MEMORANDUM

TO: Jean Fraser, Planner
FROM: David Senus, P.E.
DATE: May 13, 2015
RE: 1342 Congress Street Neighborhood Center, Preliminary Level III Site Plan Application

Woodard & Curran has reviewed the Preliminary Level III Site Plan Application response to comments submittal for the for the proposed Neighborhood Center at 1342 Congress Street. The project involves the construction of a 19,300 SF building with associated site improvements that include a surface parking lot, stormwater management system, utilities, site lighting, and landscaping. The project will disturb approximately 85,000 SF and result in 12,500 SF of additional impervious area.

SITE PLAN

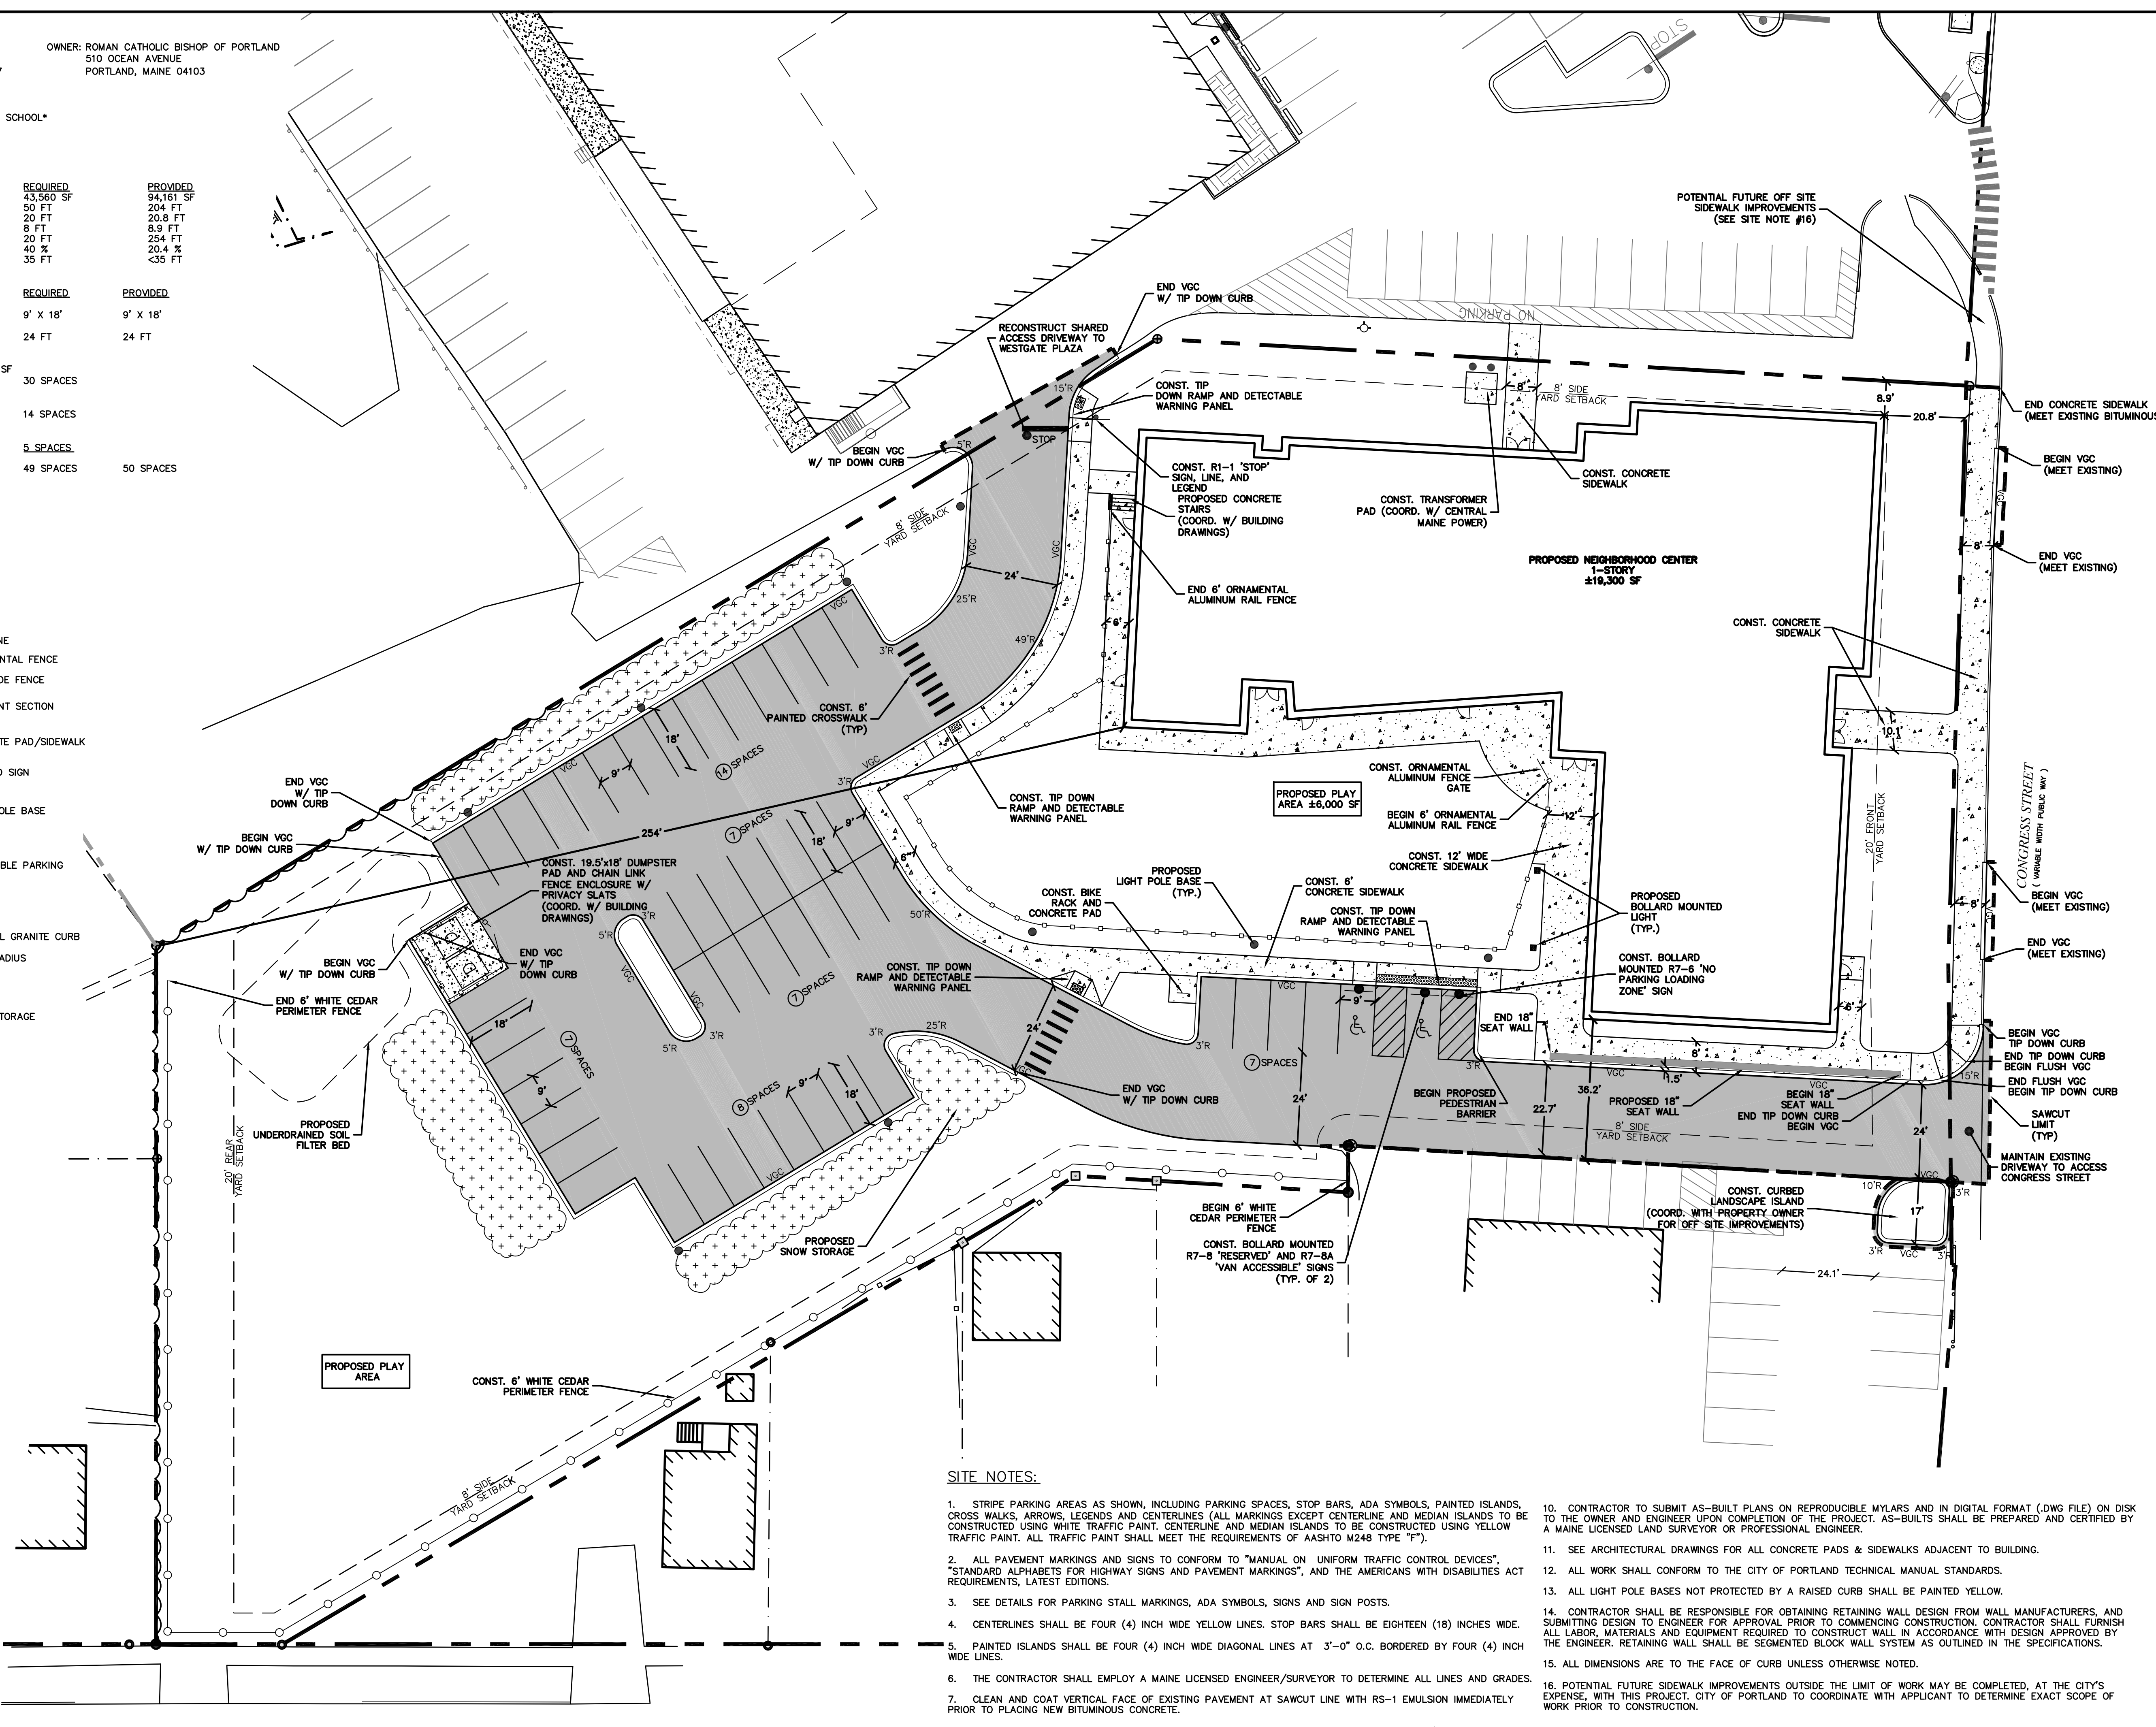
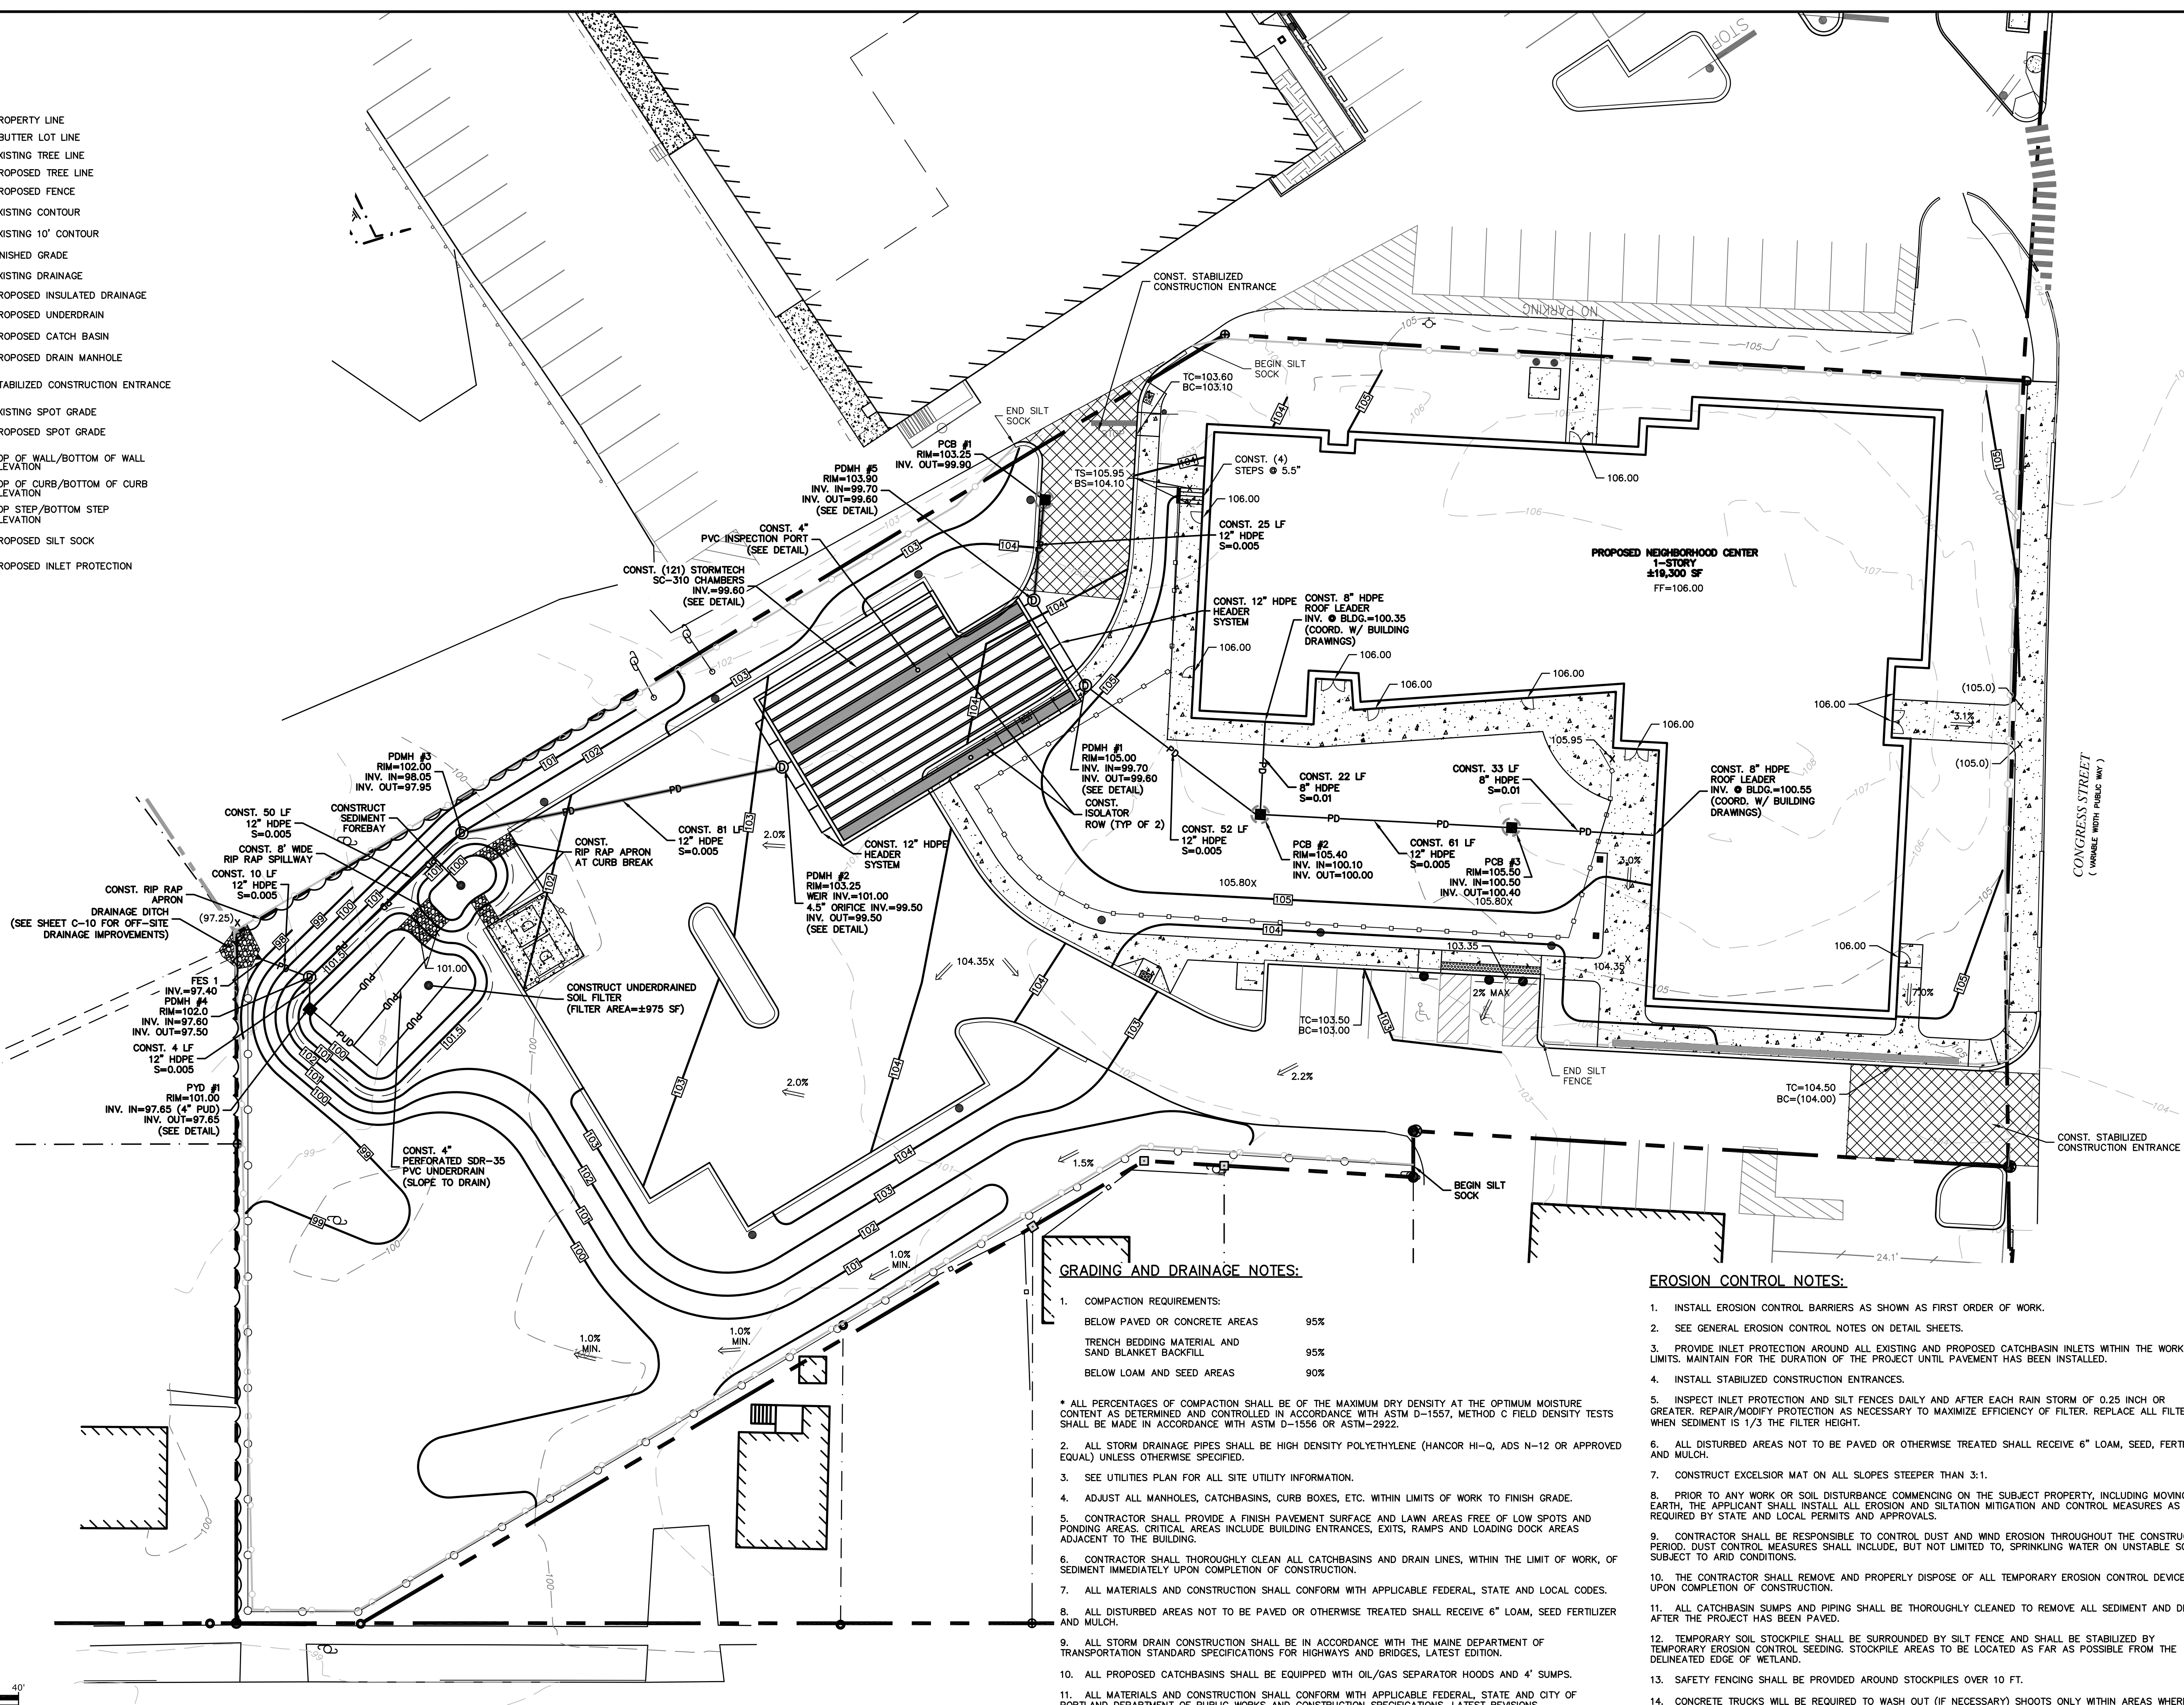
- 4) Sheet C-2b depicts snow storage along the east edge of the rear parking lot, adjacent to several residential properties. The grading plan (C-3) indicates that runoff from this area would potentially flow onto these properties. The Applicant should limit snow storage in this area and should revisit the

proposed grading to ensure that runoff from the project property is not directed onto these abutting residential lots.

Comment adequately addressed - The grading plan has been revised to provide for a shallow swale on the project property.
